Appeal Decision

Appeal Ref: APP/R4408/D/20/3251685

31 Croft Close, Mapplewell, Barnsley, South Yorkshire S75 6FN

- The appeal is made under section 78 of the Town and Country Planning Act 1990 against a refusal to grant planning permission.
 - The appeal is made by Mr James O'Callaghan against the decision of Barnsley Metropolitan Borough Council.
 - The application Ref 2019/1322, dated 15 October 2019, was refused by notice dated 3 March 2020.
 - The development proposed is single storey rear extension with a flat roof.
-

DRAWING TITLE:  
**PROPOSED ELEVATIONS**

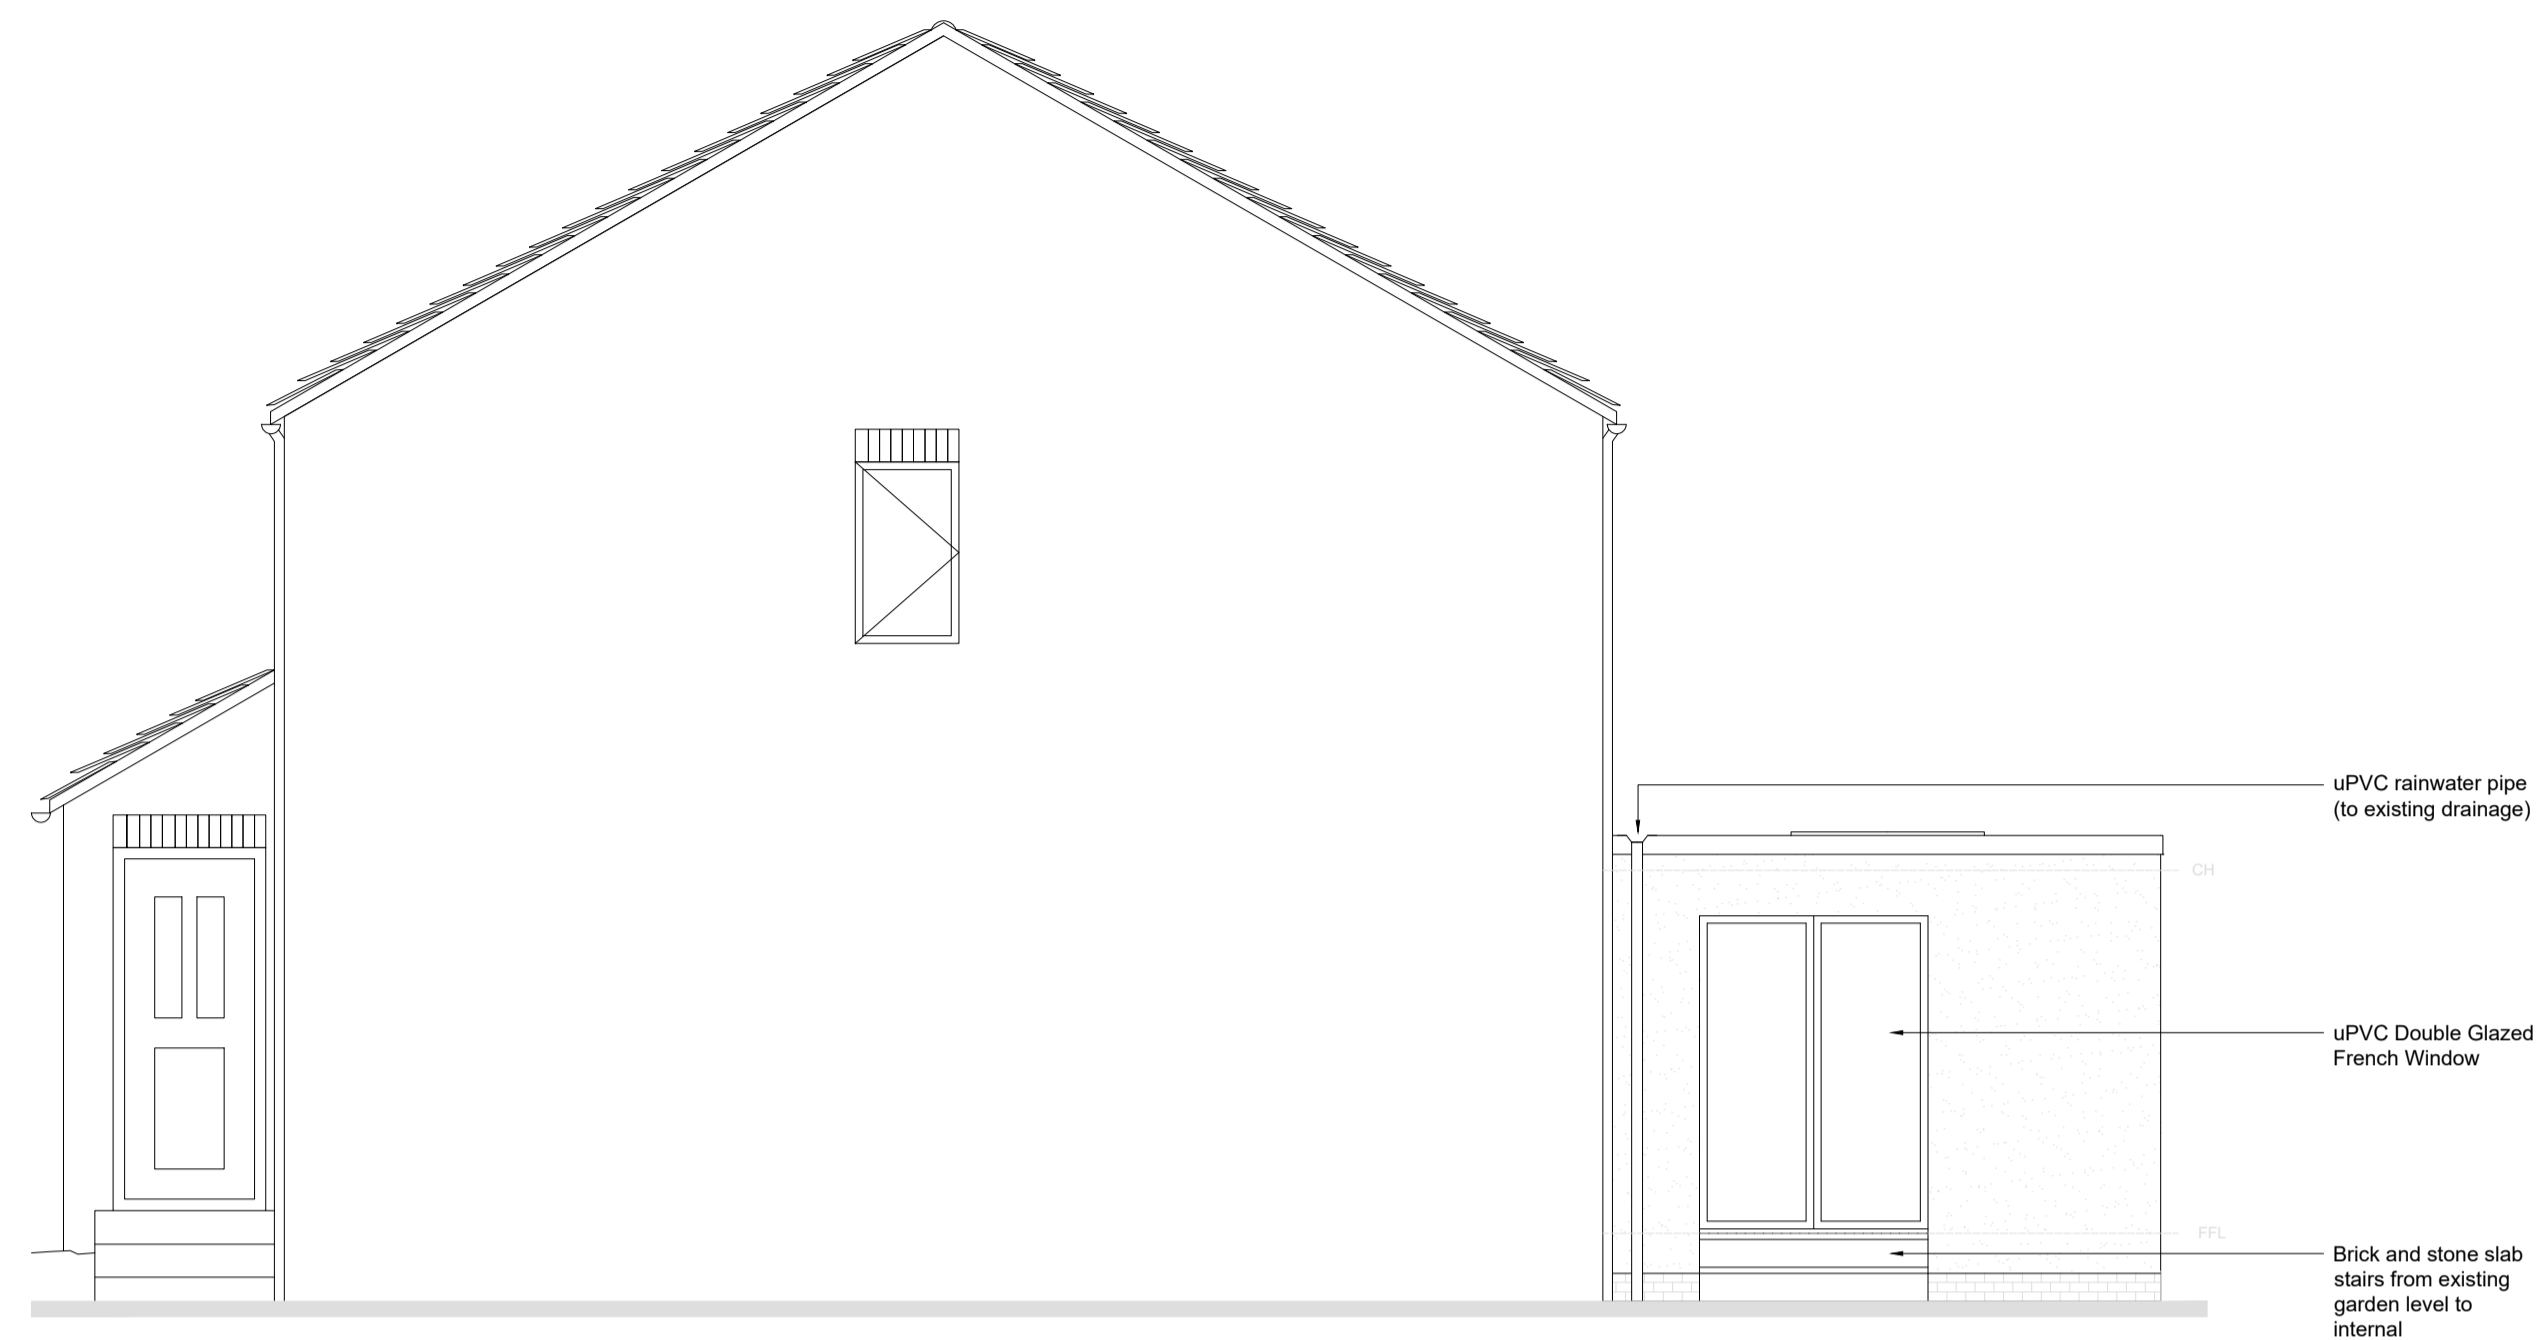
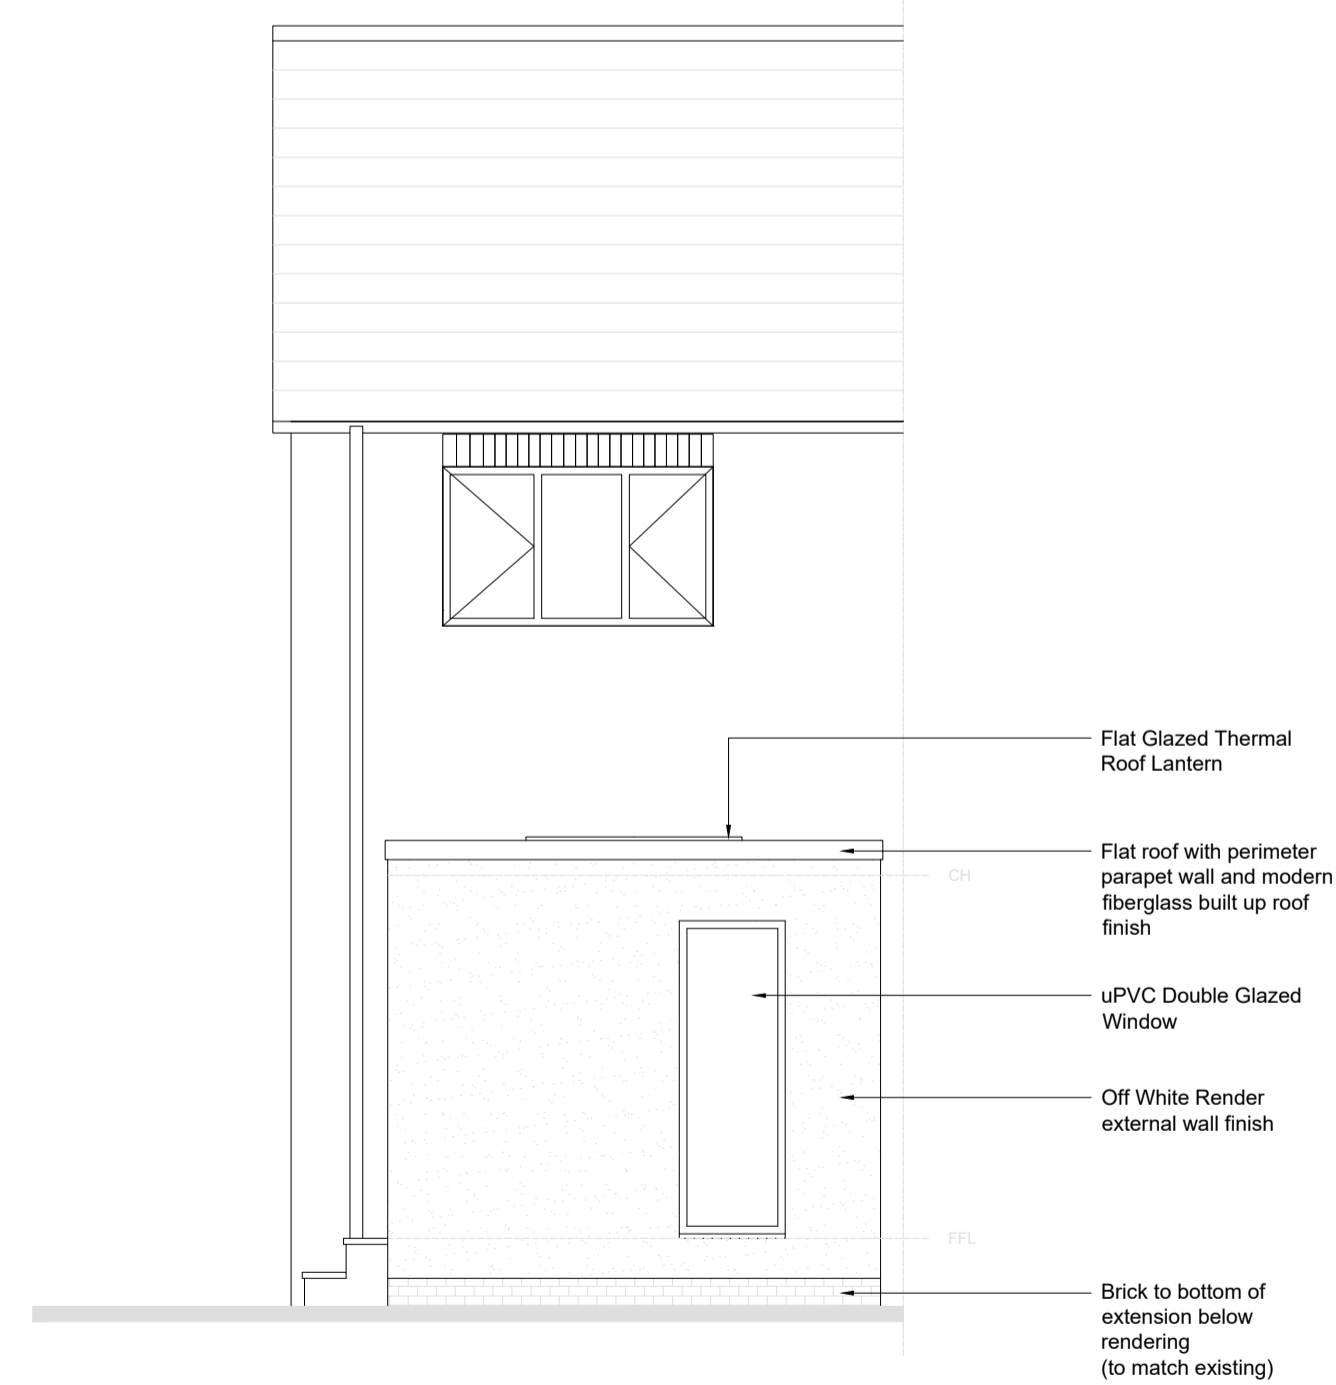
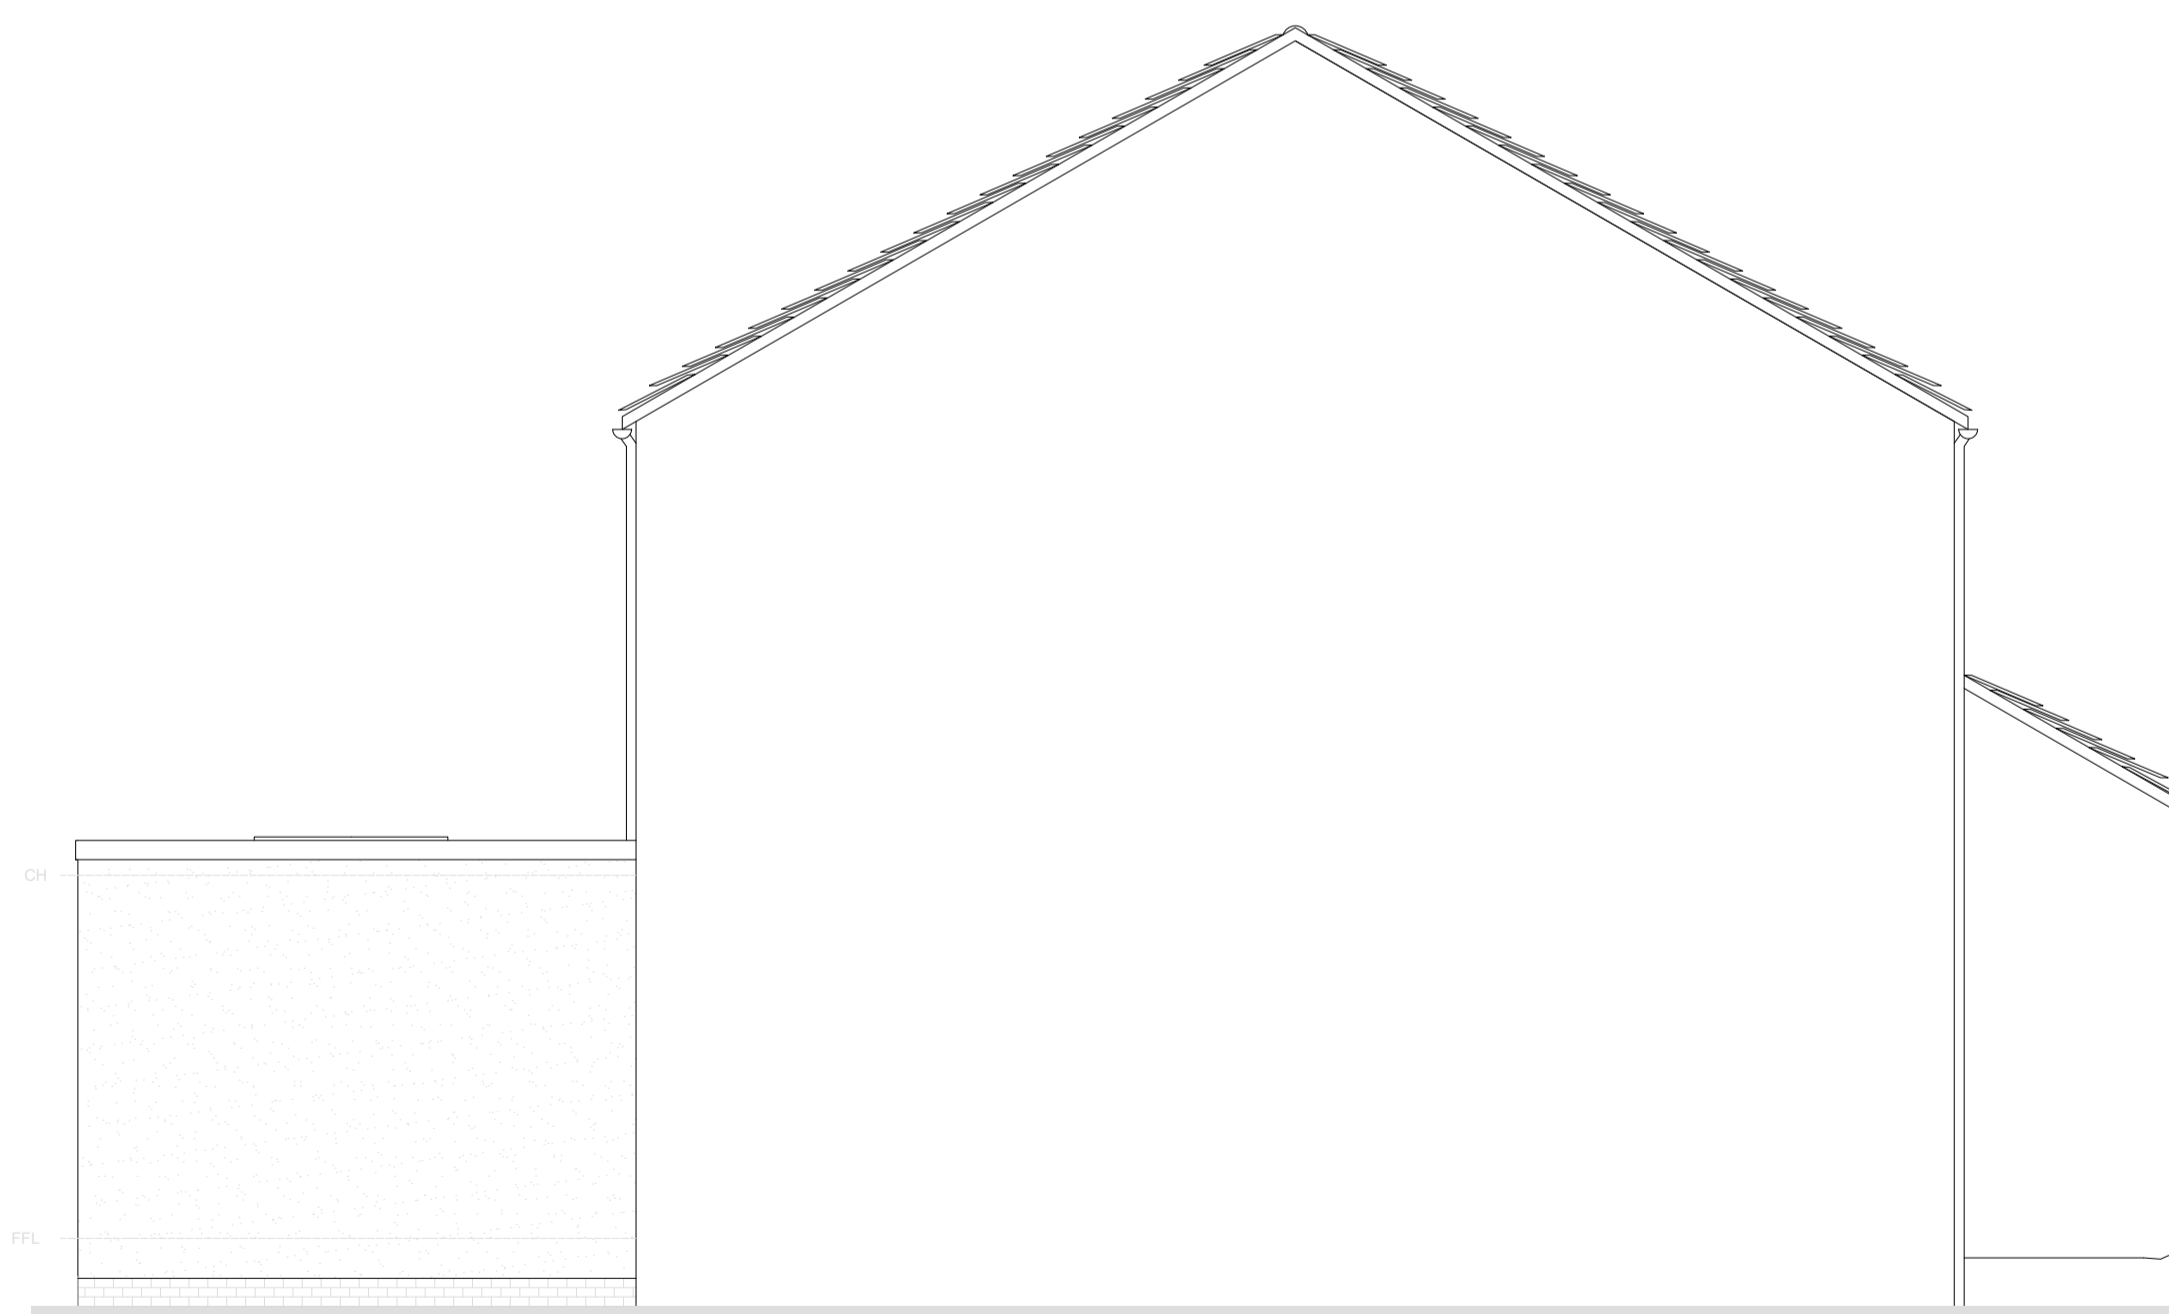
4. The appeal proposal is located in close proximity to the boundary with 29 Croft Close, which has patio doors serving a habitable room located on the rear elevation. Due to the proximity to the patio doors and the eaves height of the proposal, the extension would appear as an enclosing and overbearing feature in views from the rear of No 29. This harm would be exacerbated due to the relatively restricted outlook provided by the small rear garden at No 29 and existing outbuildings located on two sides.
5. I acknowledge that the proposal is of a relatively small scale, but this would not mitigate the harm to outlook due to the sensitive relationship with the neighbouring dwelling. Although the Council considers that the proposal would

8. Although the appeal proposal is to the rear of the property, due to the location of the site on a corner plot the extension is readily visible from the public realm. As a result of its flat roofed design, the extension appears as an obtrusive box-like addition which does not reflect the design of the host building. The proposed use of render would also contrast uncomfortably with the brick built dwelling. As an alternative, the appellant has proposed the use of matching brick slips, but this would not satisfactorily mitigate the unsympathetic design of the extension.

9. The appellant submits that the use of a pitched roof may increase the eaves height with subsequent harm to the outlook from No 29. However, this indicates the fundamentally inappropriate nature of this proposal in this sensitive location.
